Application No: Y/5/26/PL
Site Address: 2 Downview Road Yapton BN18 0HS
Description of works: Erection of terrace of 4 No town houses with gardens and parking spaces. This application is in CIL Zone 2 and is CIL Liable as new dwellings.

Thank you for your internet representation made on 25th March 2026 which has been recorded as an objection with the comments as follows:

2 Downview Road, Yapton : Proposed 4-unit 3-storey Terrace of 3-bedroom Dwellinghouses : PROPOSED SITE LAYOUT

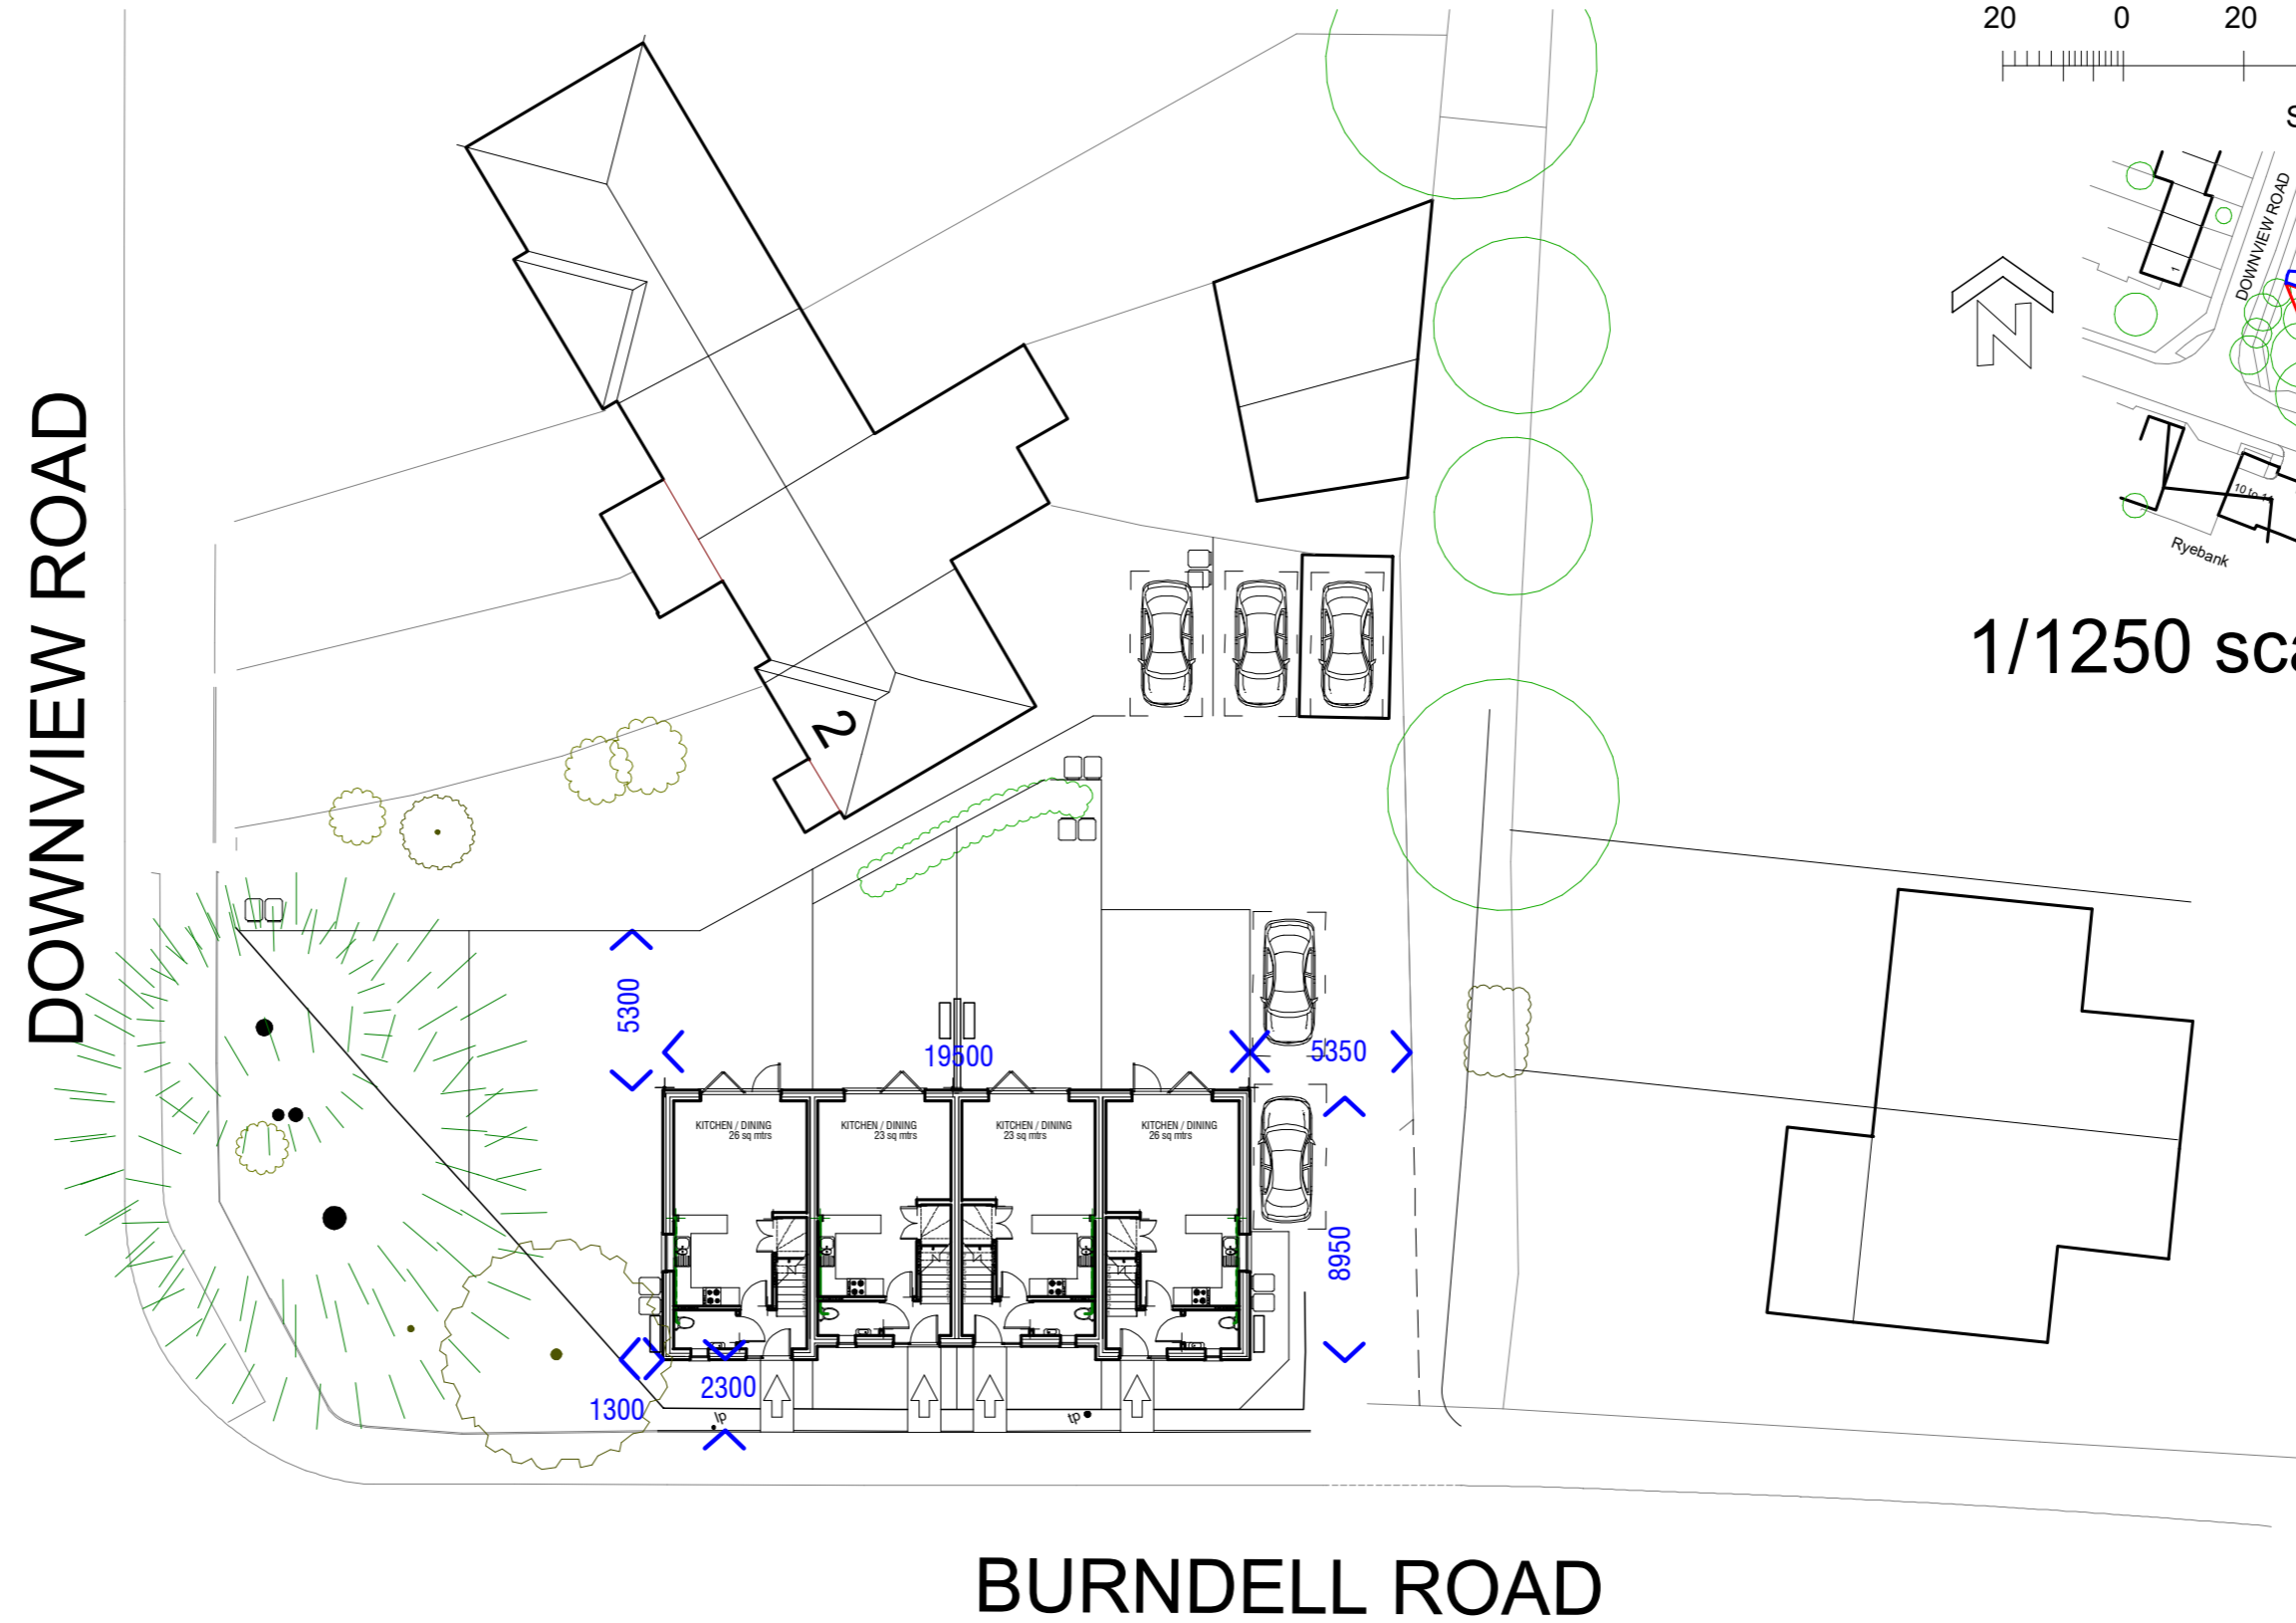
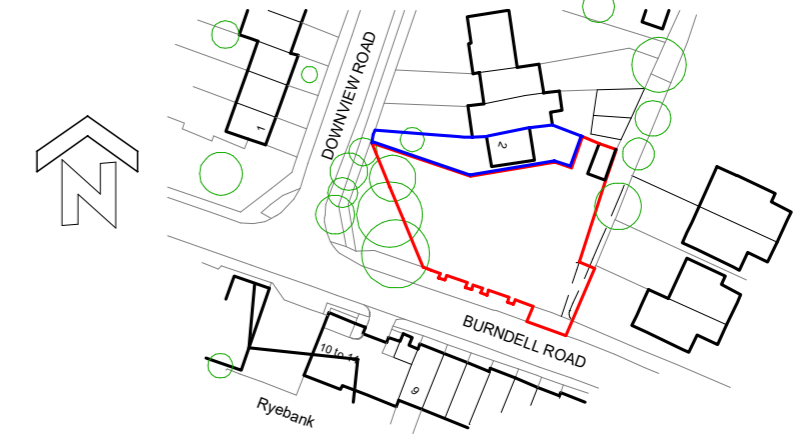
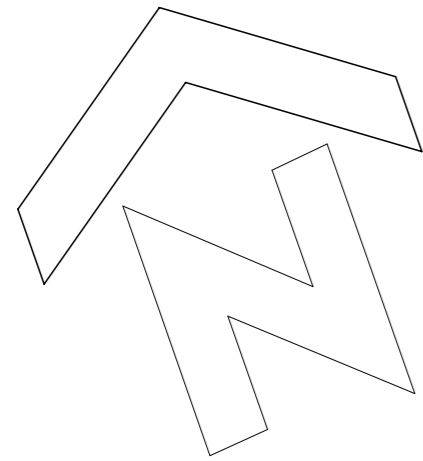
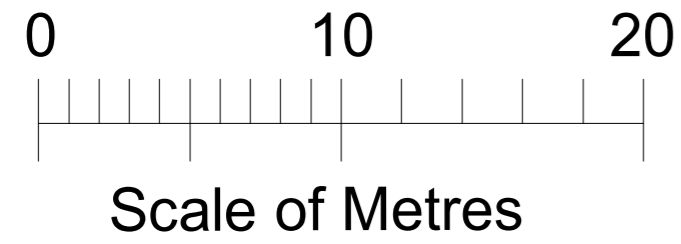
I object to the planning application because the entrance to the carpark spaces are too close to the entrance to Downview Road and the flats opposite causing more congestion. This building would also obstruct the light to the houses on the left of Downview road.
